**WEST SUSSEX COUNTY COUNCIL
STRATEGIC PLANNING CONSULTATION**

SUBJECT: Y/72/14/PD - Prior Notification under class J for change of use from class B1a to Class C3 dwellinghouse.

Unit A Orchard Barn, Church Lane, Yapton, West Sussex, BN18 0EH

Drwg: 2013/01 AB Scale 1:500

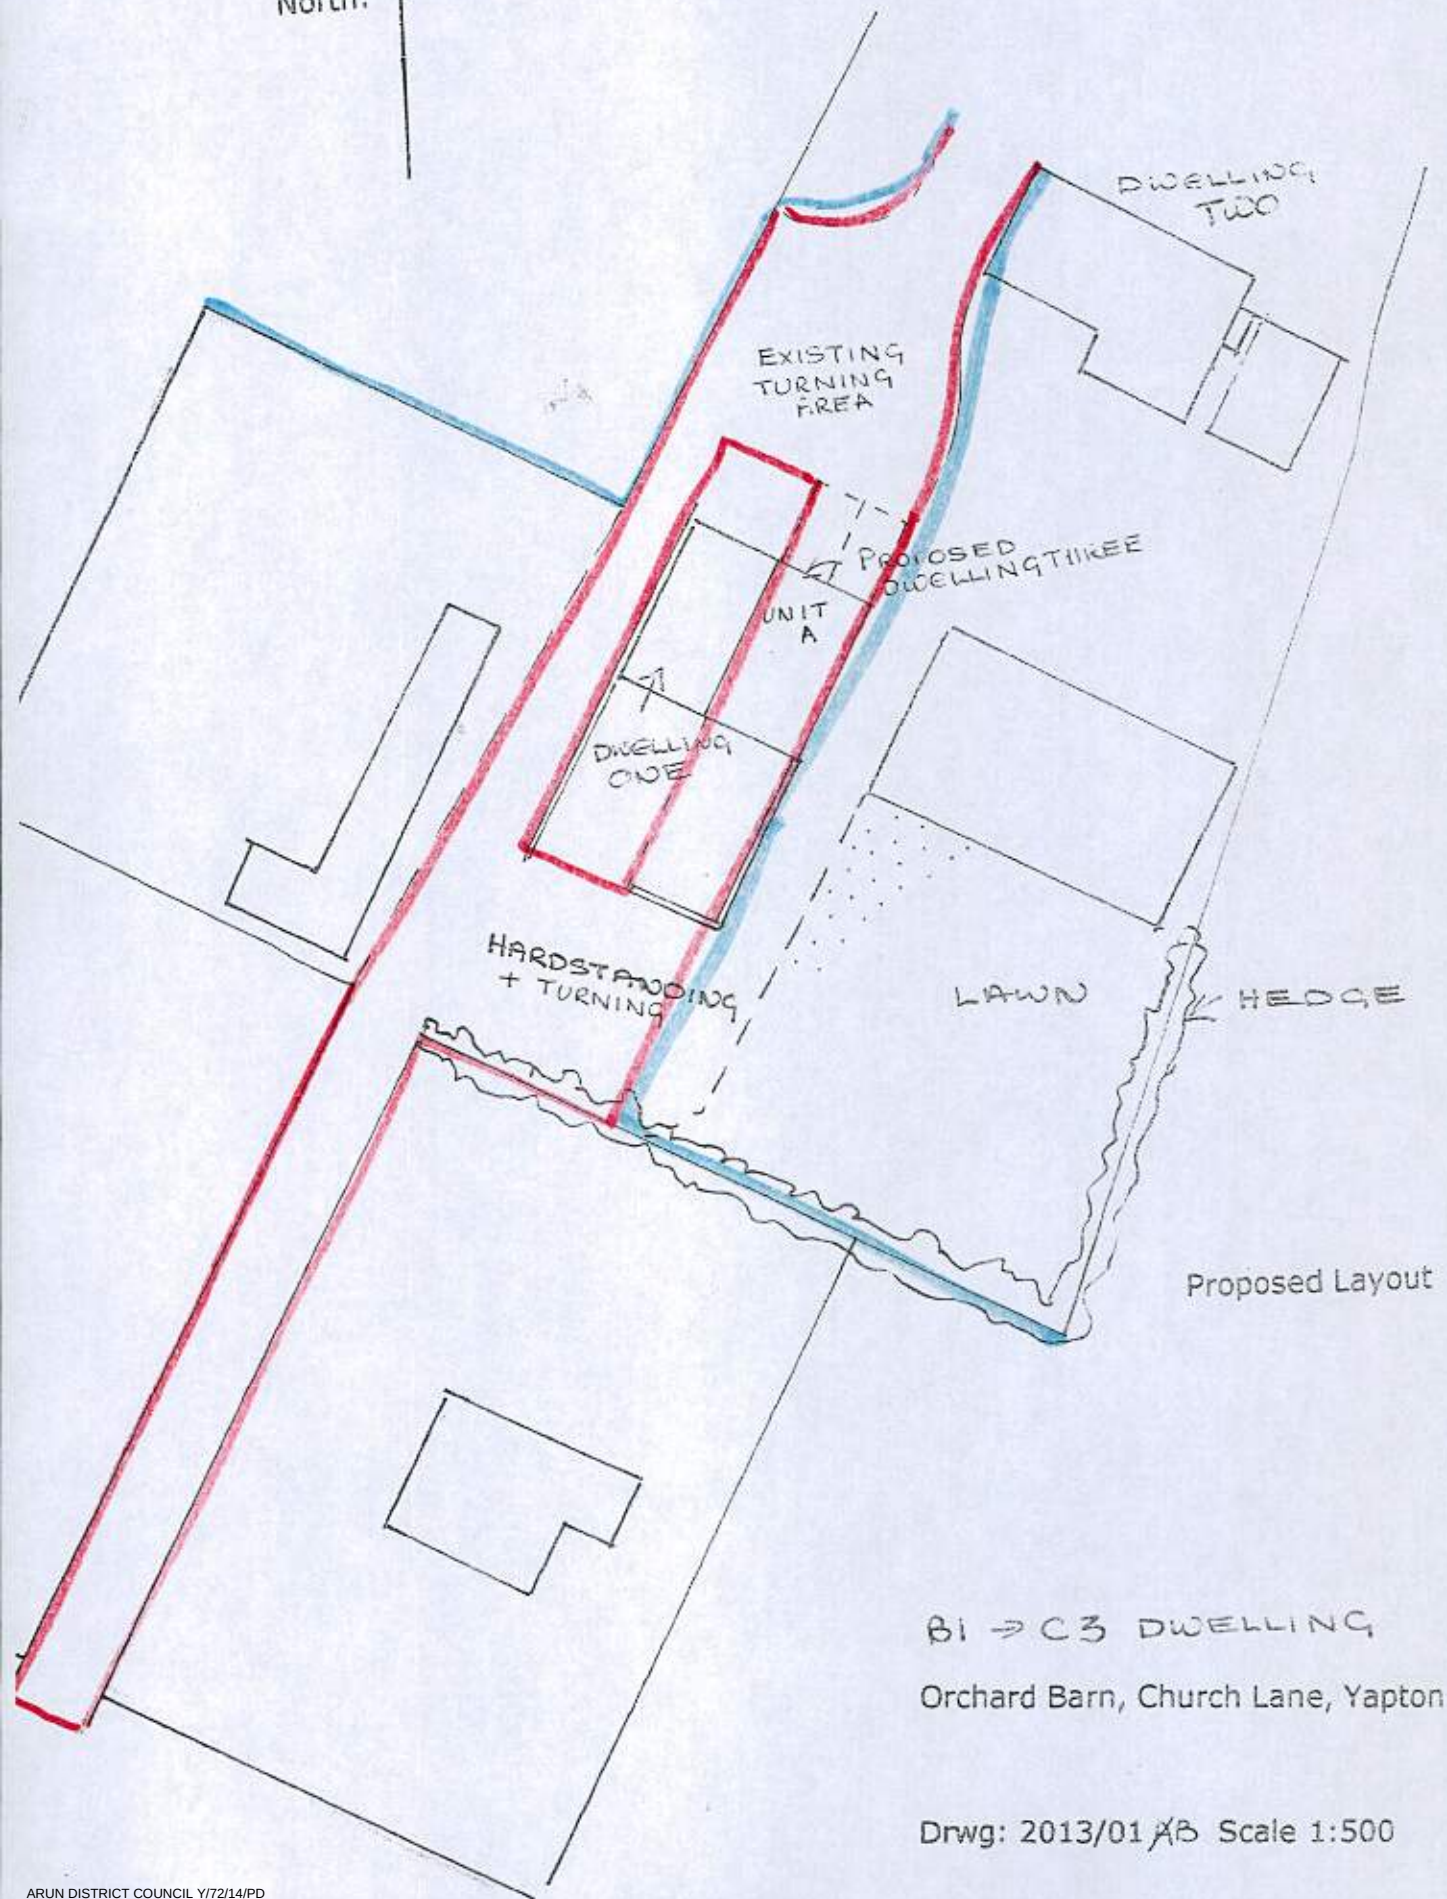
The application seeks approval for the change in use of an existing B1 (a) unit to form a C3 dwelling house. From inspection of the plans and information available, the site is situated in private land that is accessed via two existing private tracks that are sufficient to support this change in use. There is suitable parking and turning areas included within the proposals that are adequate to support the size of the unit in this location.

No concerns would be raised to this application from a highways perspective subject to a condition securing secure and covered cycle parking.
